Re: Rice/McGonagil Residence, 505 Camino Espanol NW,

Request for Permanent C.O. –Accepted

Engineer's Stamp dated: 03-23-12, (E14/D007)

Re: Rice McGonagil Residence Grading and Drainage Plan

sheet title	GRADING & DRAINAGE PLAN
-------------	-------------------------

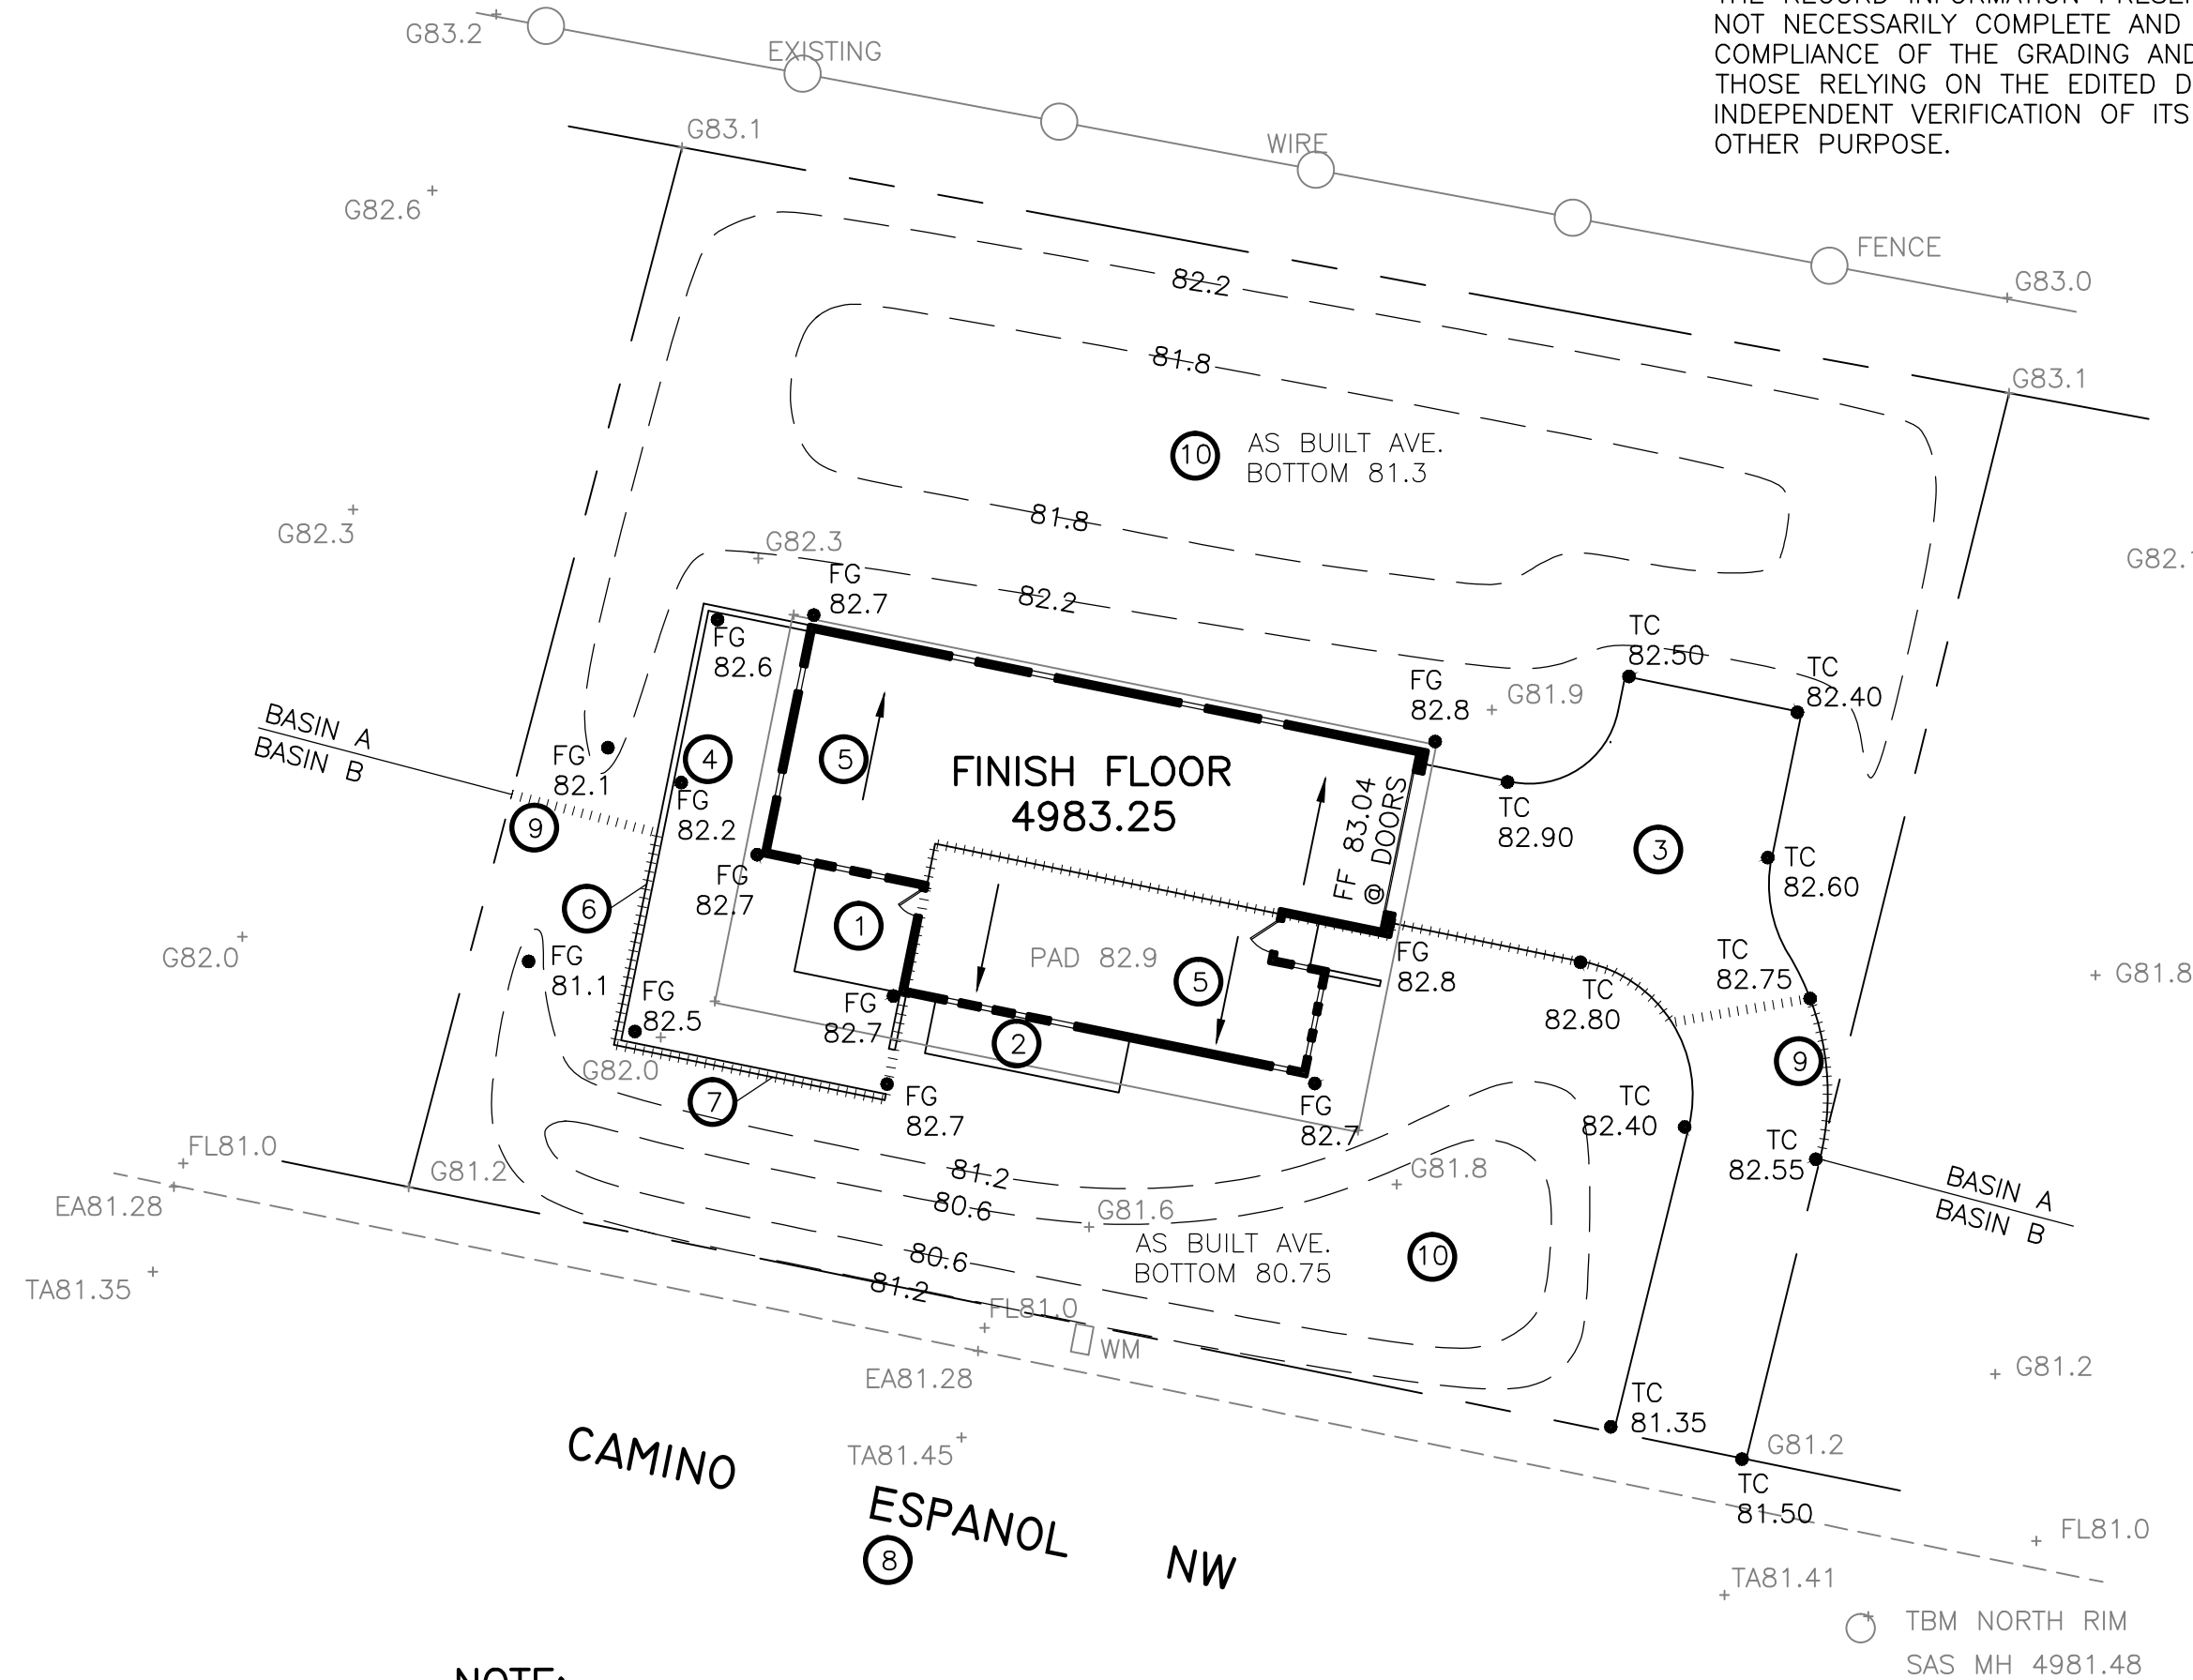
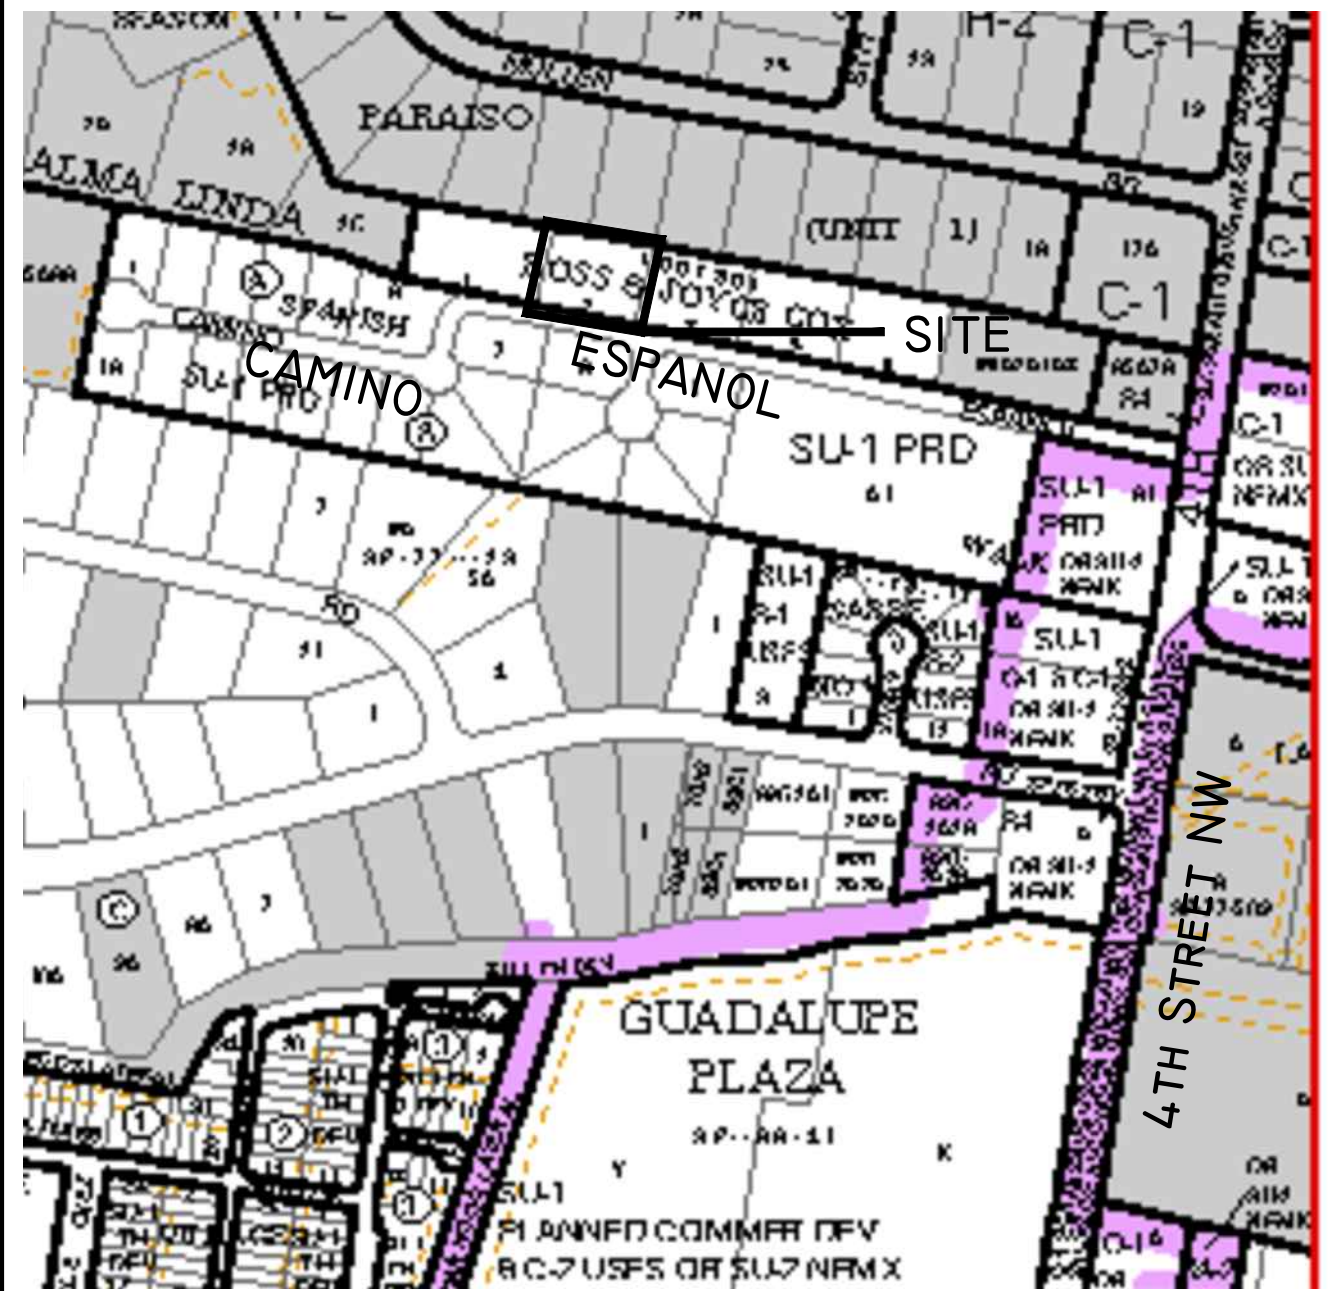
- Street names on the Vicinity Map are not clear. Please mark the location of the site on the Vicinity Map.
- Call out wall openings for the proposed wall on the west side of the building.

- Basin B top of pond is 82.3 under the volume calculations and on the plan view is 82.20.
- Provide proposed grades in front of the garage (+/- 82.75'). Top of concrete just east of the garage is at 82.90. Therefore, the runoff appear to be draining towards the garage.

- Note 3 should be used instead of Note 6 for the proposed driveway.
- Total area under the proposed conditions is more that existing conditions.
- Provide 10 year/6 hour volume calculations under proposed conditions. Volume increase appears to be more than what is called under the "GRADING NOTES".

- Need to lower top of Basin B Pond to allow the runoff from the street enter the pond. Bottom of the pond had two different elevations (80.70 & 81.00).

- Clearly show the limits of Basin A and B.

1. This is a copy of the Zone Atlas sheet and is difficult to read. The site has been marked and I have tried to make the street names more obvious.
- ✓ 2. The back yard has been regarded and the wall opening has been noted.
- ✓ 3. The grades have changed to agree.
- ✓ 4. The slab elevation at the garage doors has been added to assure positive drainage.
- ✓ 5. The note number on the driveway has been changed.
- ✓ 6. I have corrected both the existing condition areas.
- ✓ 7. I have added the 10 year developed storm values. *check Basin A reg'd vol.*
- ✓ 8. I lowered the top of Pond B.
9. I changed the line type for the Basin Boundary to make it more obvious. *A Flows into B?*
